Wentworthville Public School Redevelopment (SSD 9273)

Applicant Response to Submissions

1 PLAN
TREE PLAN
SCALE: 1:500

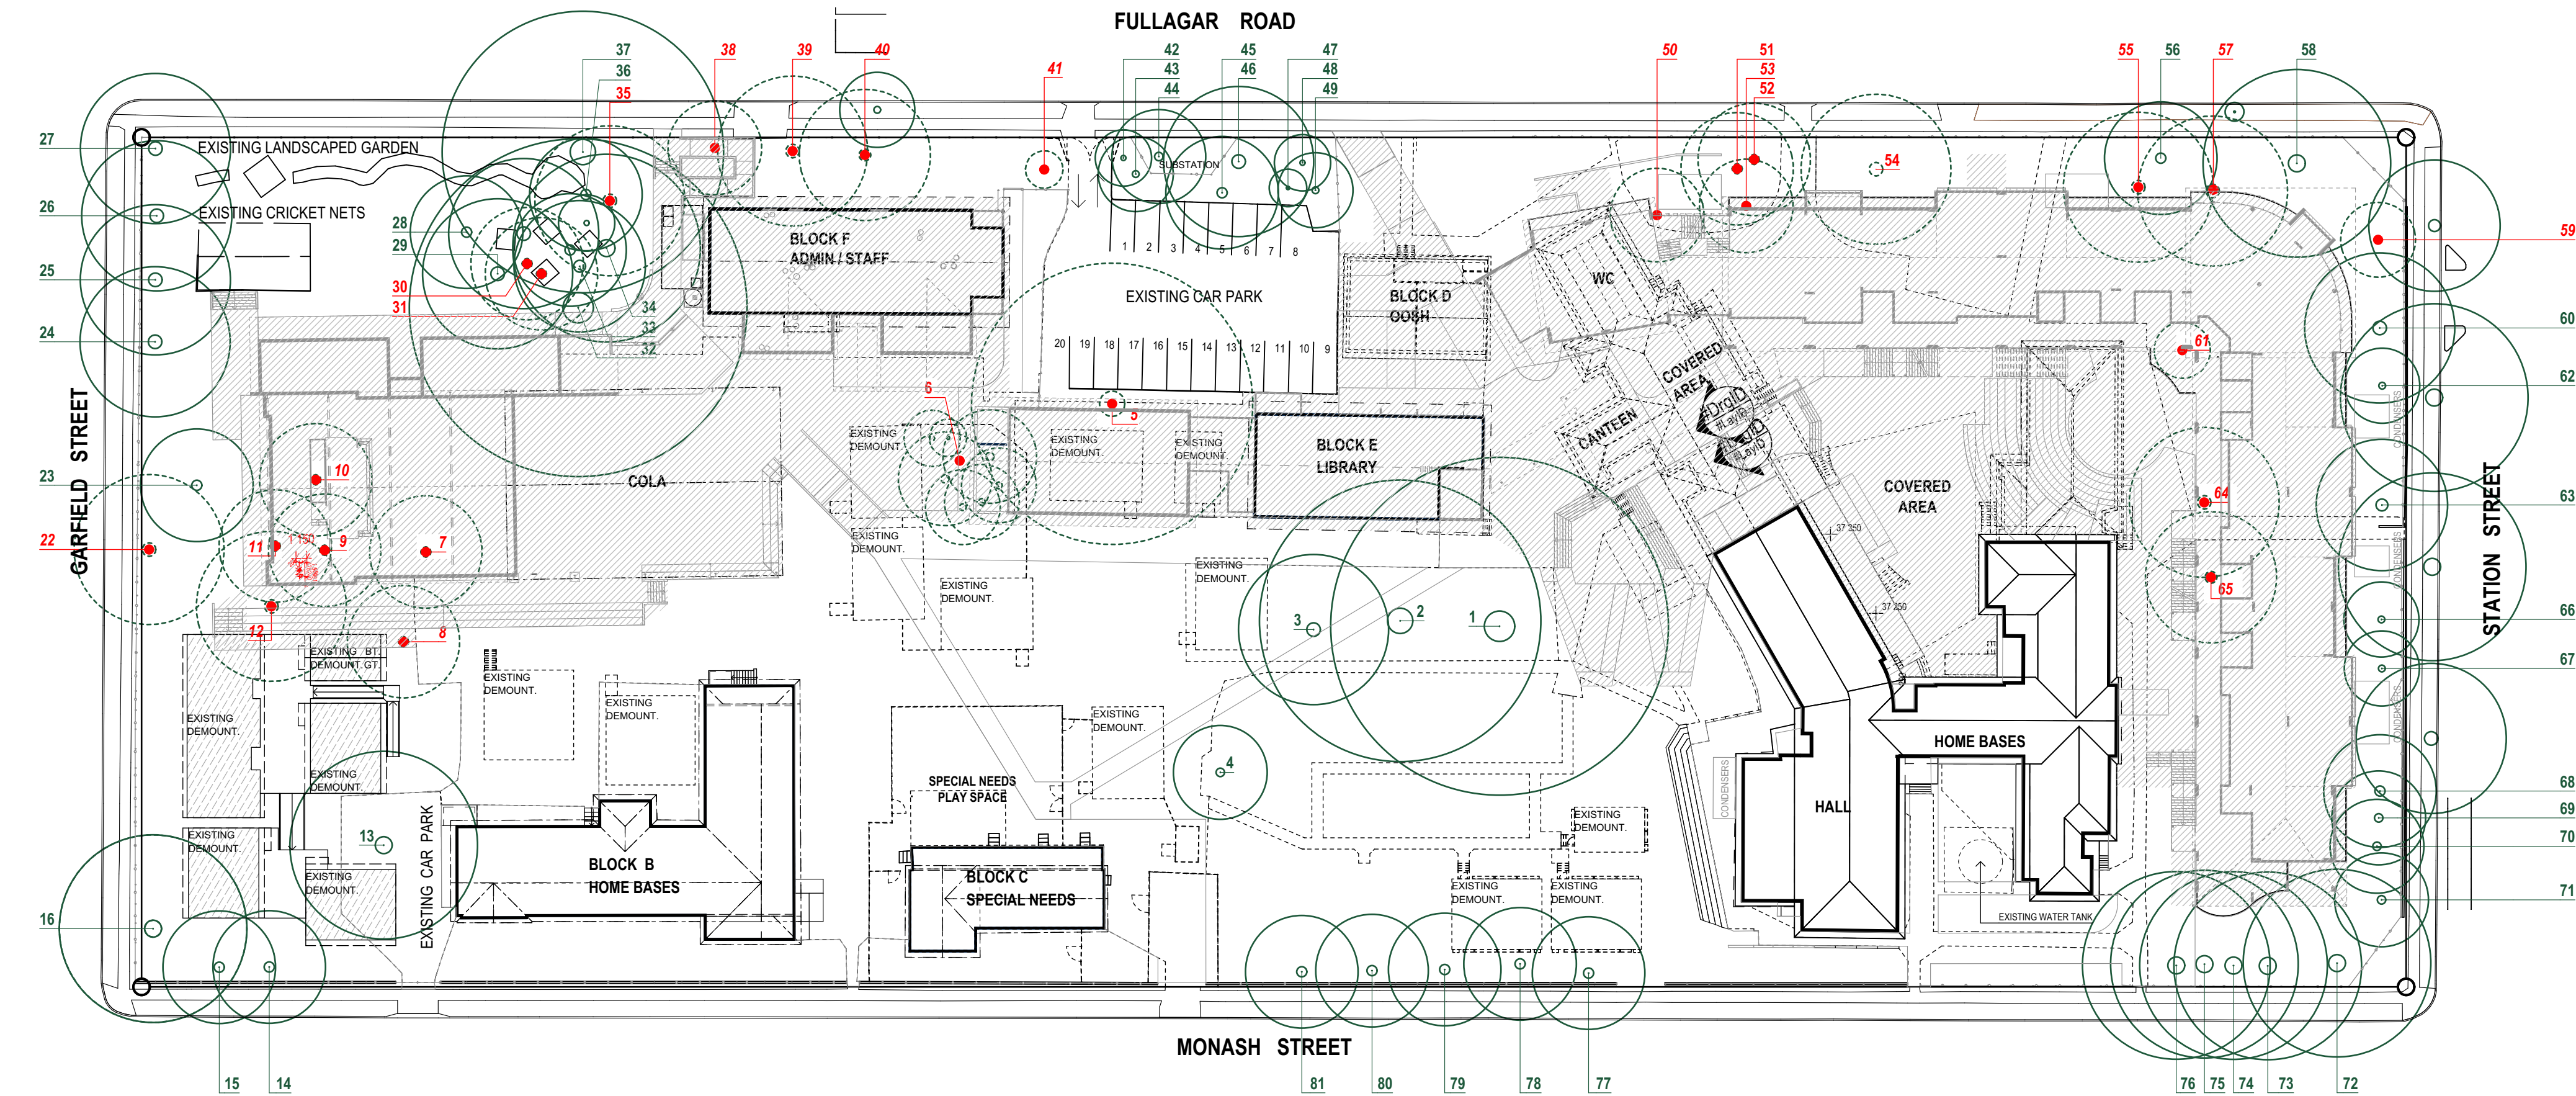
Item No.	Government Agency	Agency Comment	Applicant Response	Relevant Attachment
70		Tree Retention and Under Tree Canopy Cover - The plans show conflicting information on the extent of tree removal / retention. The arborist reports site demolition plan in Appendix A1 and Tree removal/retention plans – Appendix A2ii conflict with the Landscape Plans tree removal and retention plan. The arborist report plans are unreadable making it difficult to determine which trees correspond with the tree numbers and the condition of the trees as detailed in the tables in the arborist report.	Please find attached a revised issue of the Arborist Report, a revised issue of the Existing Tree Plan from the Landscape Architect (drawing LDA-06) as well as a revised issue of the Architectural Tree Plan (drawing SD-1609). These plans and reports have now been updated to accurately reflect the extent of trees being proposed for removal as part of this project.	Attachment E - Amended Arboricultural Impact Assessment Report prepared by TreeTalk Arboricultural Consulting and dated February 2019. Attachment F - Revised Landscape Plan prepared by Ground Ink and dated 7/2/19.
